From: Sue Howell <Sue.Howell@arun.gov.uk>
Sent: 21 April 2021 18:23
To: Planning.Responses <Planning.Responses@arun.gov.uk>
Cc: Michael Eastham <Michael.Eastham@arun.gov.uk>
Subject: FW: Planning Consultation on: A/31/21/PL

Application ref: A/31/21/PL

Description: Variation of Conditions following grant of A/109/20/RES relating to Condition No 1 plans - Arboricultural Impact Assessment and Arboricultural Method Statement and Condition No 7 - tree protection plan.

Location: Land South of Water Lane Angmering

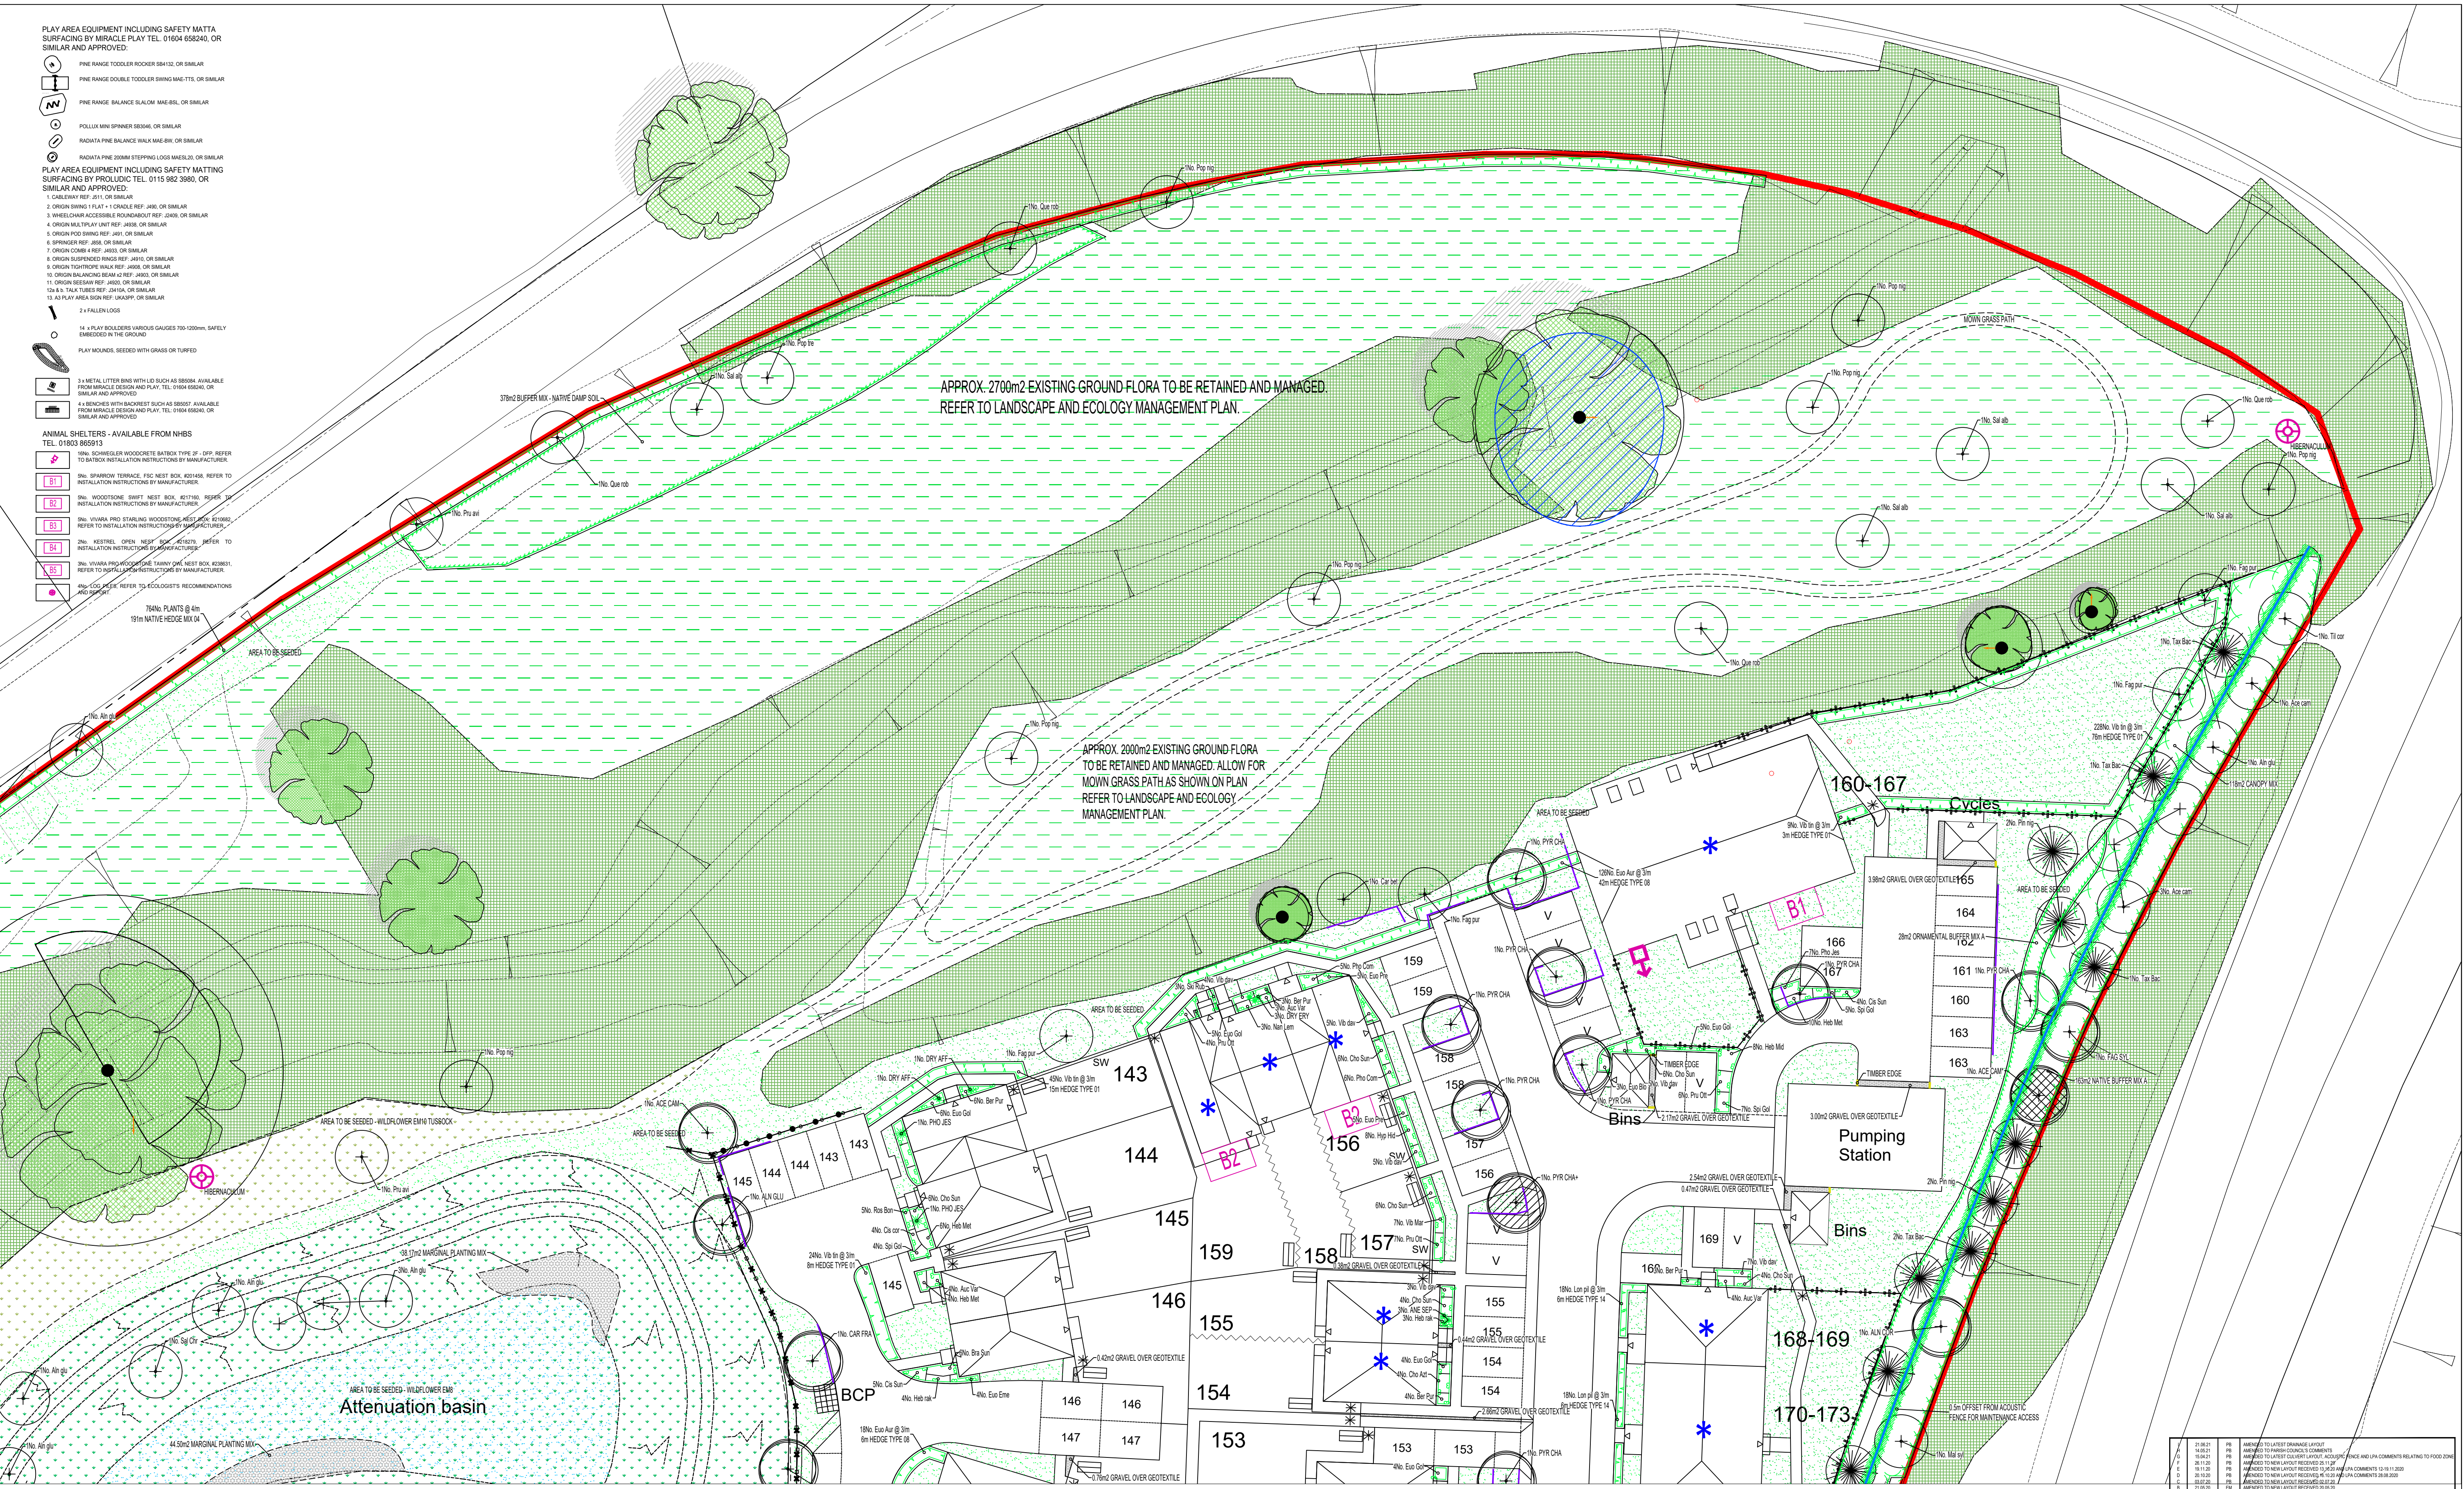
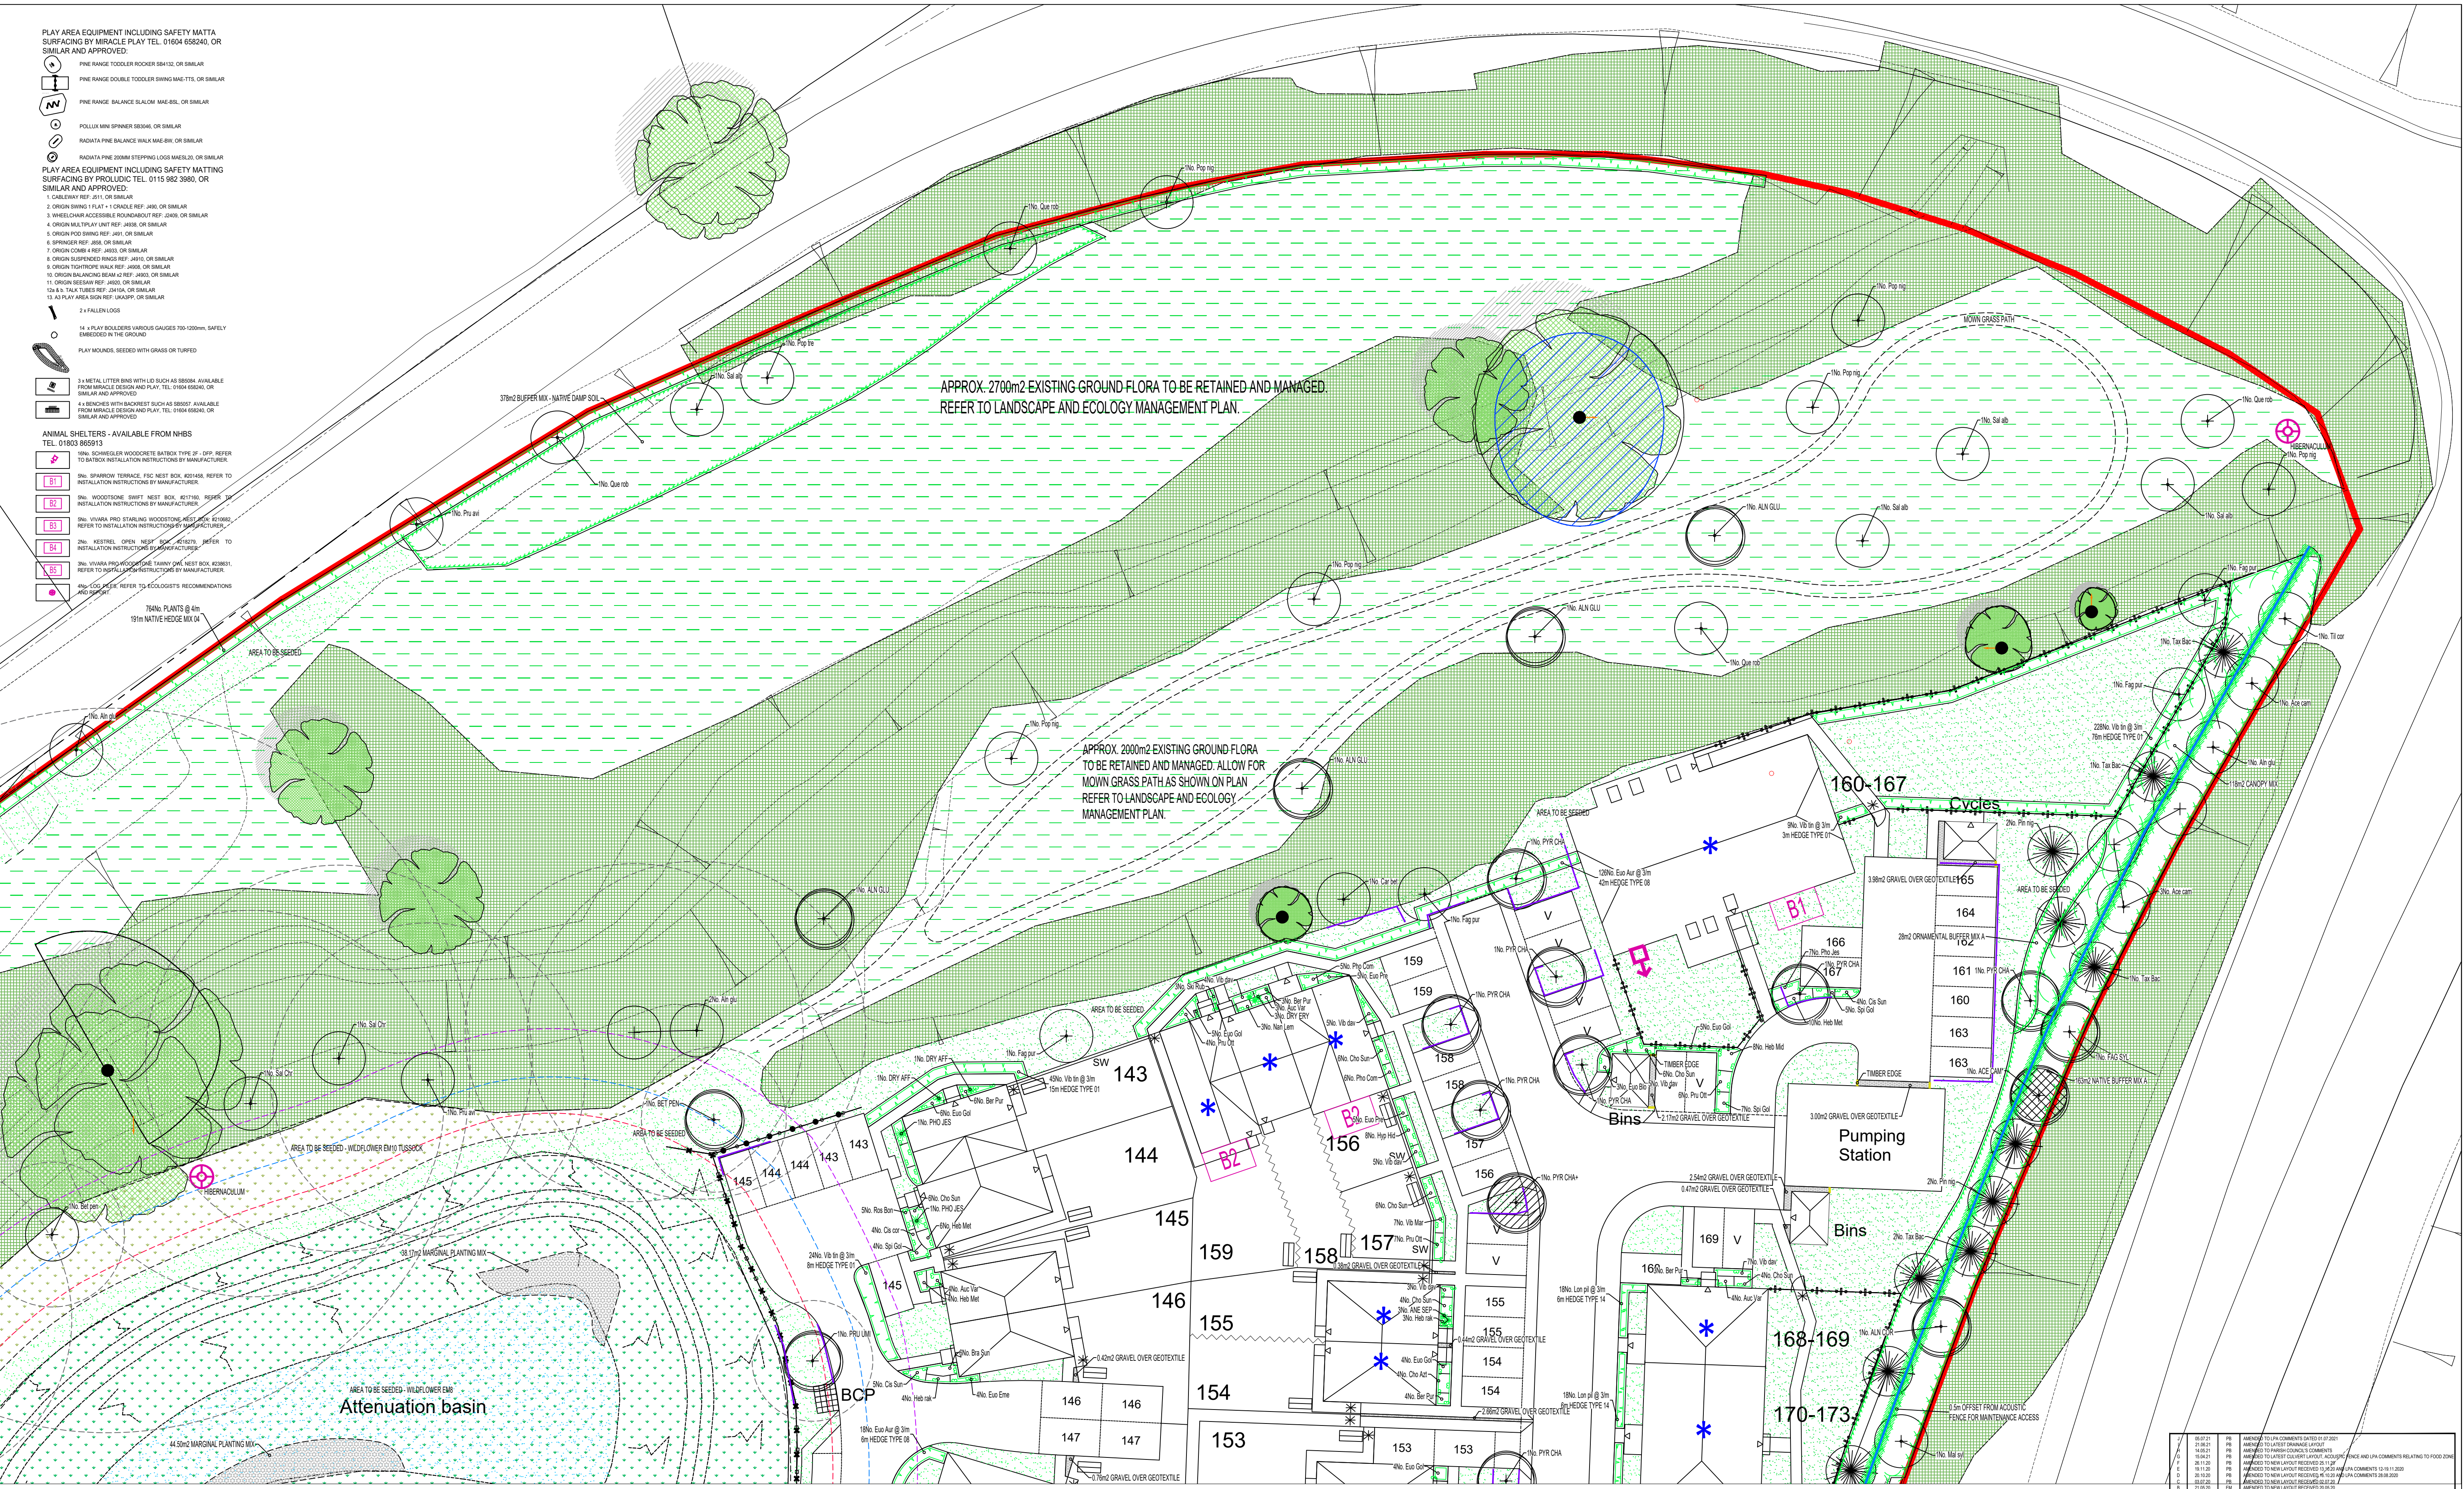
These comments relate to revised information submitted within dwgs JBA-19-283-01 Angmering detailed Plots and POS **Rev G** and JBA-19-283-02 Angmering detailed Plots and POS **Rev G**.

The revisions appear to have taken on board concerns re the wetland area/ ditch landscaping re species choice and location for the planting of these. The tree planting proposal now within Rev G have proposed suitable water tolerant species which have been sited largely into the periphery of this area, avoiding direct conflict with the culverts, the attenuation area and excluding planting into areas where it would be envisaged that year-round standing water would occur. One hundred-year storm events should not pose significant harm to trees in these revised locations, assuming that they do not fall within permanently wet areas or for continued periods of time.

The use of species such as alder and willow at lower levels has been proposed; known for favouring the prevailing conditions and which ought to survive any short term flooding event.

The established existing trees and scrub in this area with particular note the significant TPO'd Oak T55 need to be protected from harm including avoiding increased ground water levels with any proposed or changed drainage provision in this location. These already established features within the landscape provide invaluable habitat and aesthetic resource.

Raised winter water levels across the flood plain; if were to occur, even as a singular event and reach established trees of low floodwater tolerance, would be to the detriment of several landscape features, most notably a preserved oak (T55) Recommend that clarification is sought from the Drainage Engineer re the potential for this occurring post construction.

Landscape provision as set out in Dwgs JBA-19-283-01 Angmering detailed Plots and POS Rev G and JBA-19-283-02 Angmering detailed Plots and POS Rev G. would appear appropriate for location.
